Application for Removal or Variation of a Condition following Grant of Planning Permission or
Listed Building Consent

Oast House South of Scarletts

Conversion of derelict Oast House and reinstatement of west stowage to form 1 no. residential dwelling.

19/00589/FUL

dwg no. 266_P(P)_003

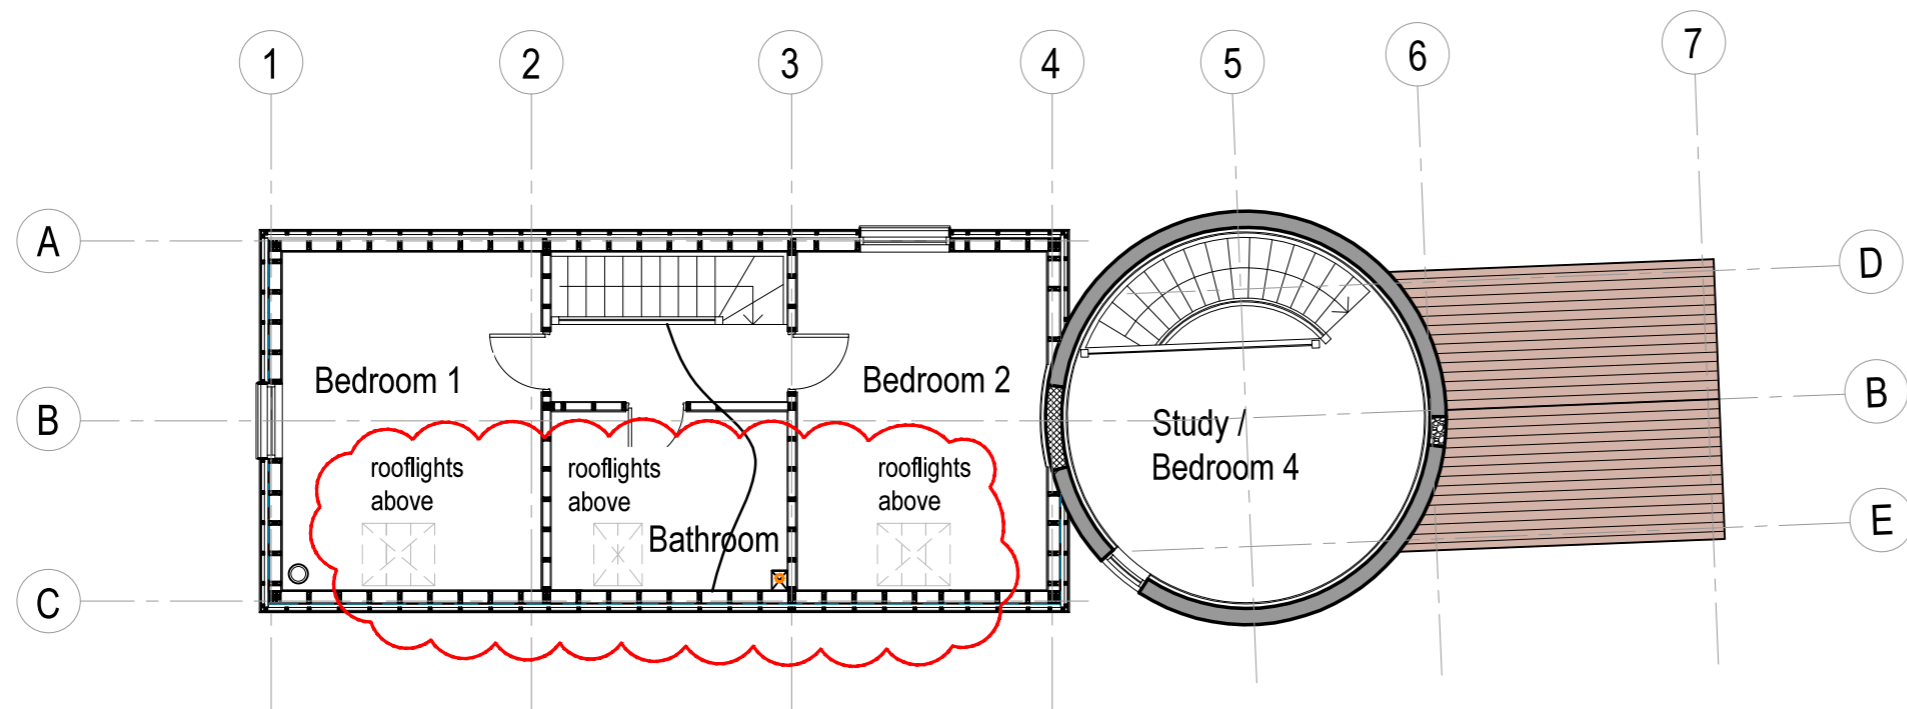
Supersede drawing No's:
266_P(P)_002: Oast House Proposed Plans - Roof
266_P(P)_003: Oast House Proposed Plans - First Floor
266_P(P)_005: Oast House Proposed Elevations - South & West

266_P(P)_003: Oast House Proposed Plans - First Floor - Rev A

dwg no. 266_P(P)_002

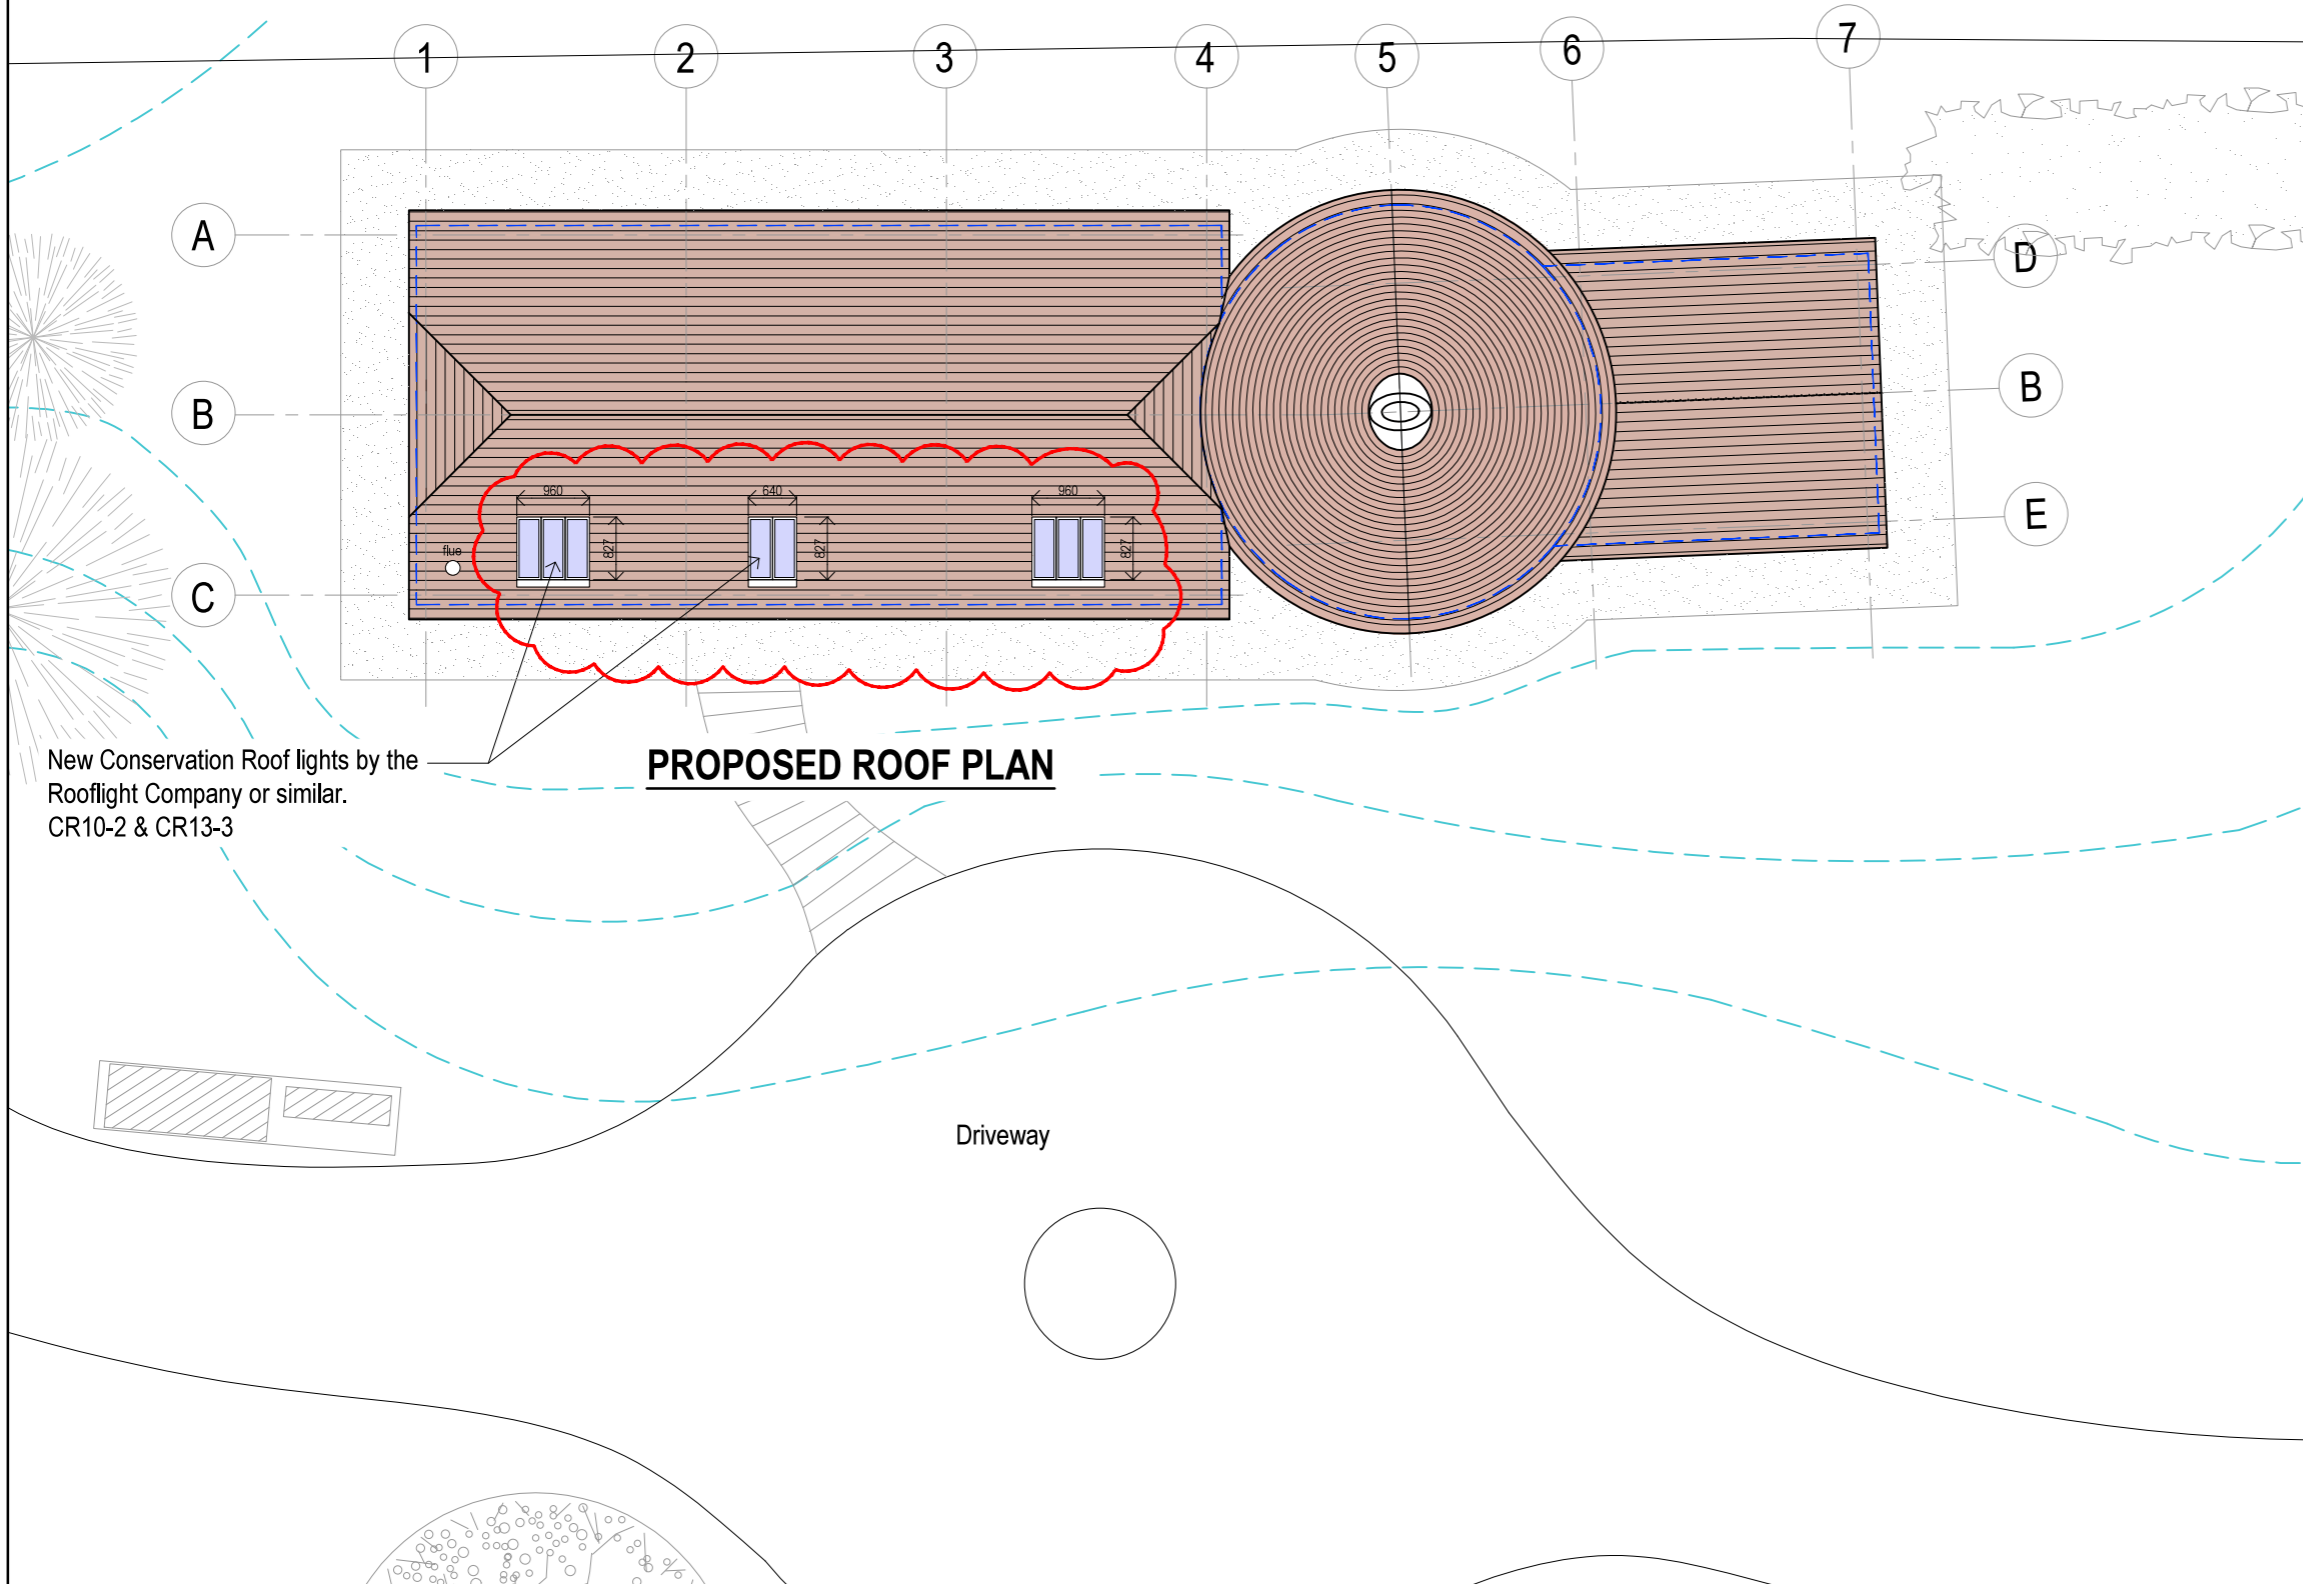
266_P(P)_002: Oast House Proposed Plans - Roof - Rev A

266_P(P)_005

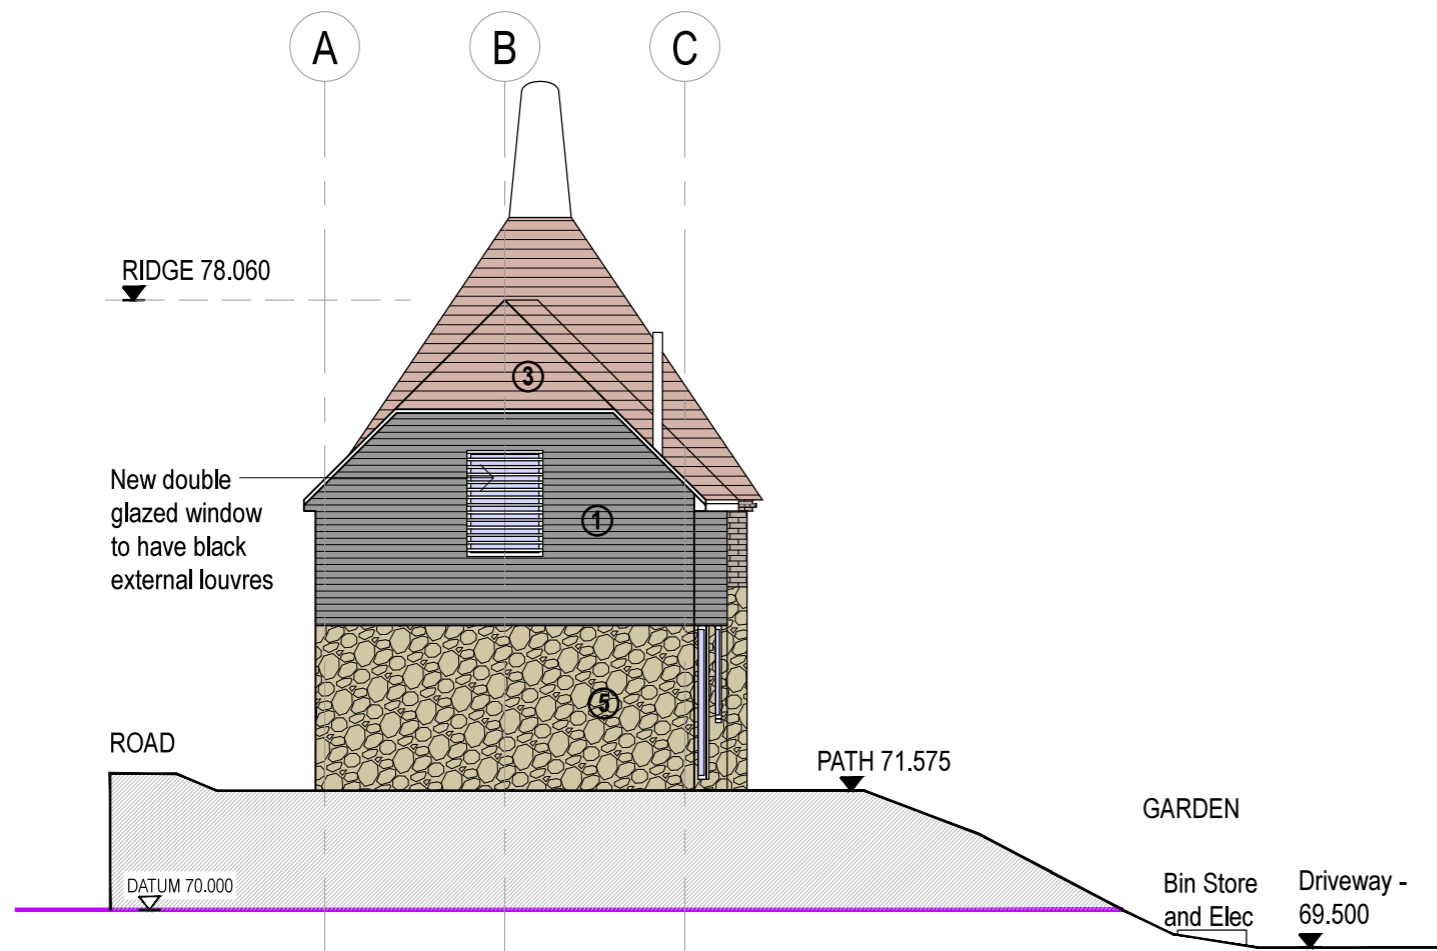
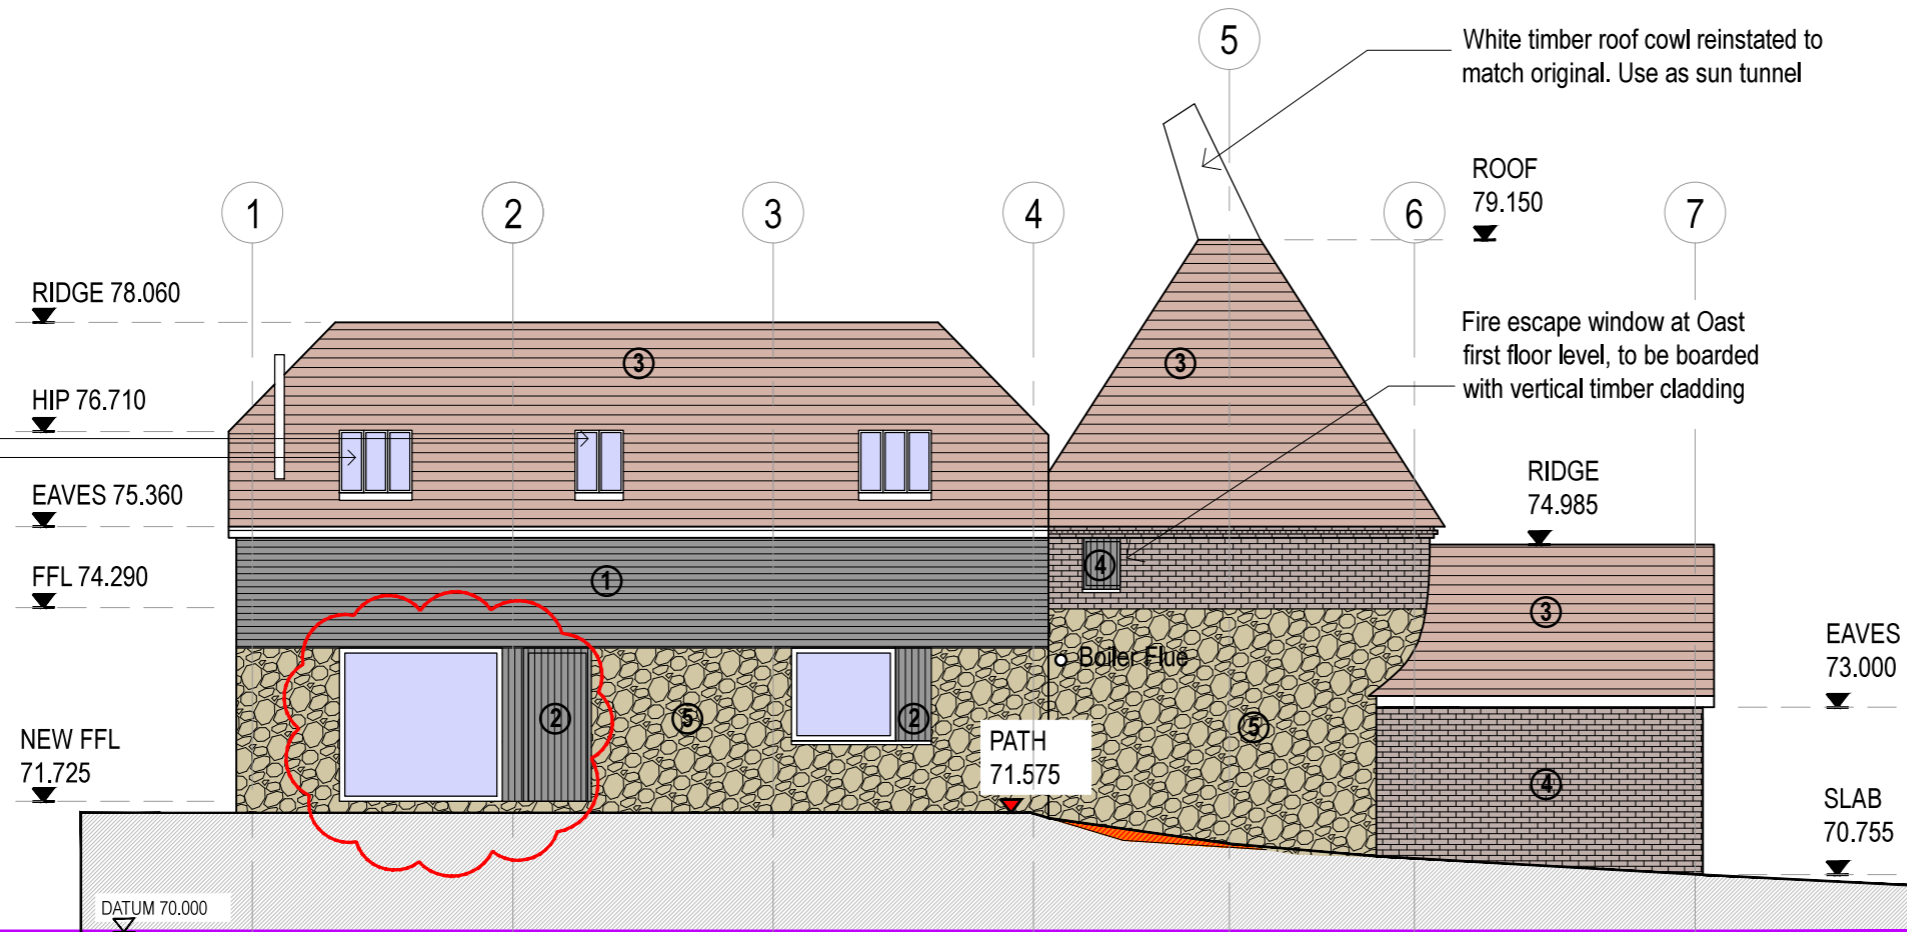
266_P(P)_005: Oast House Proposed Elevations - South & West - Rev A
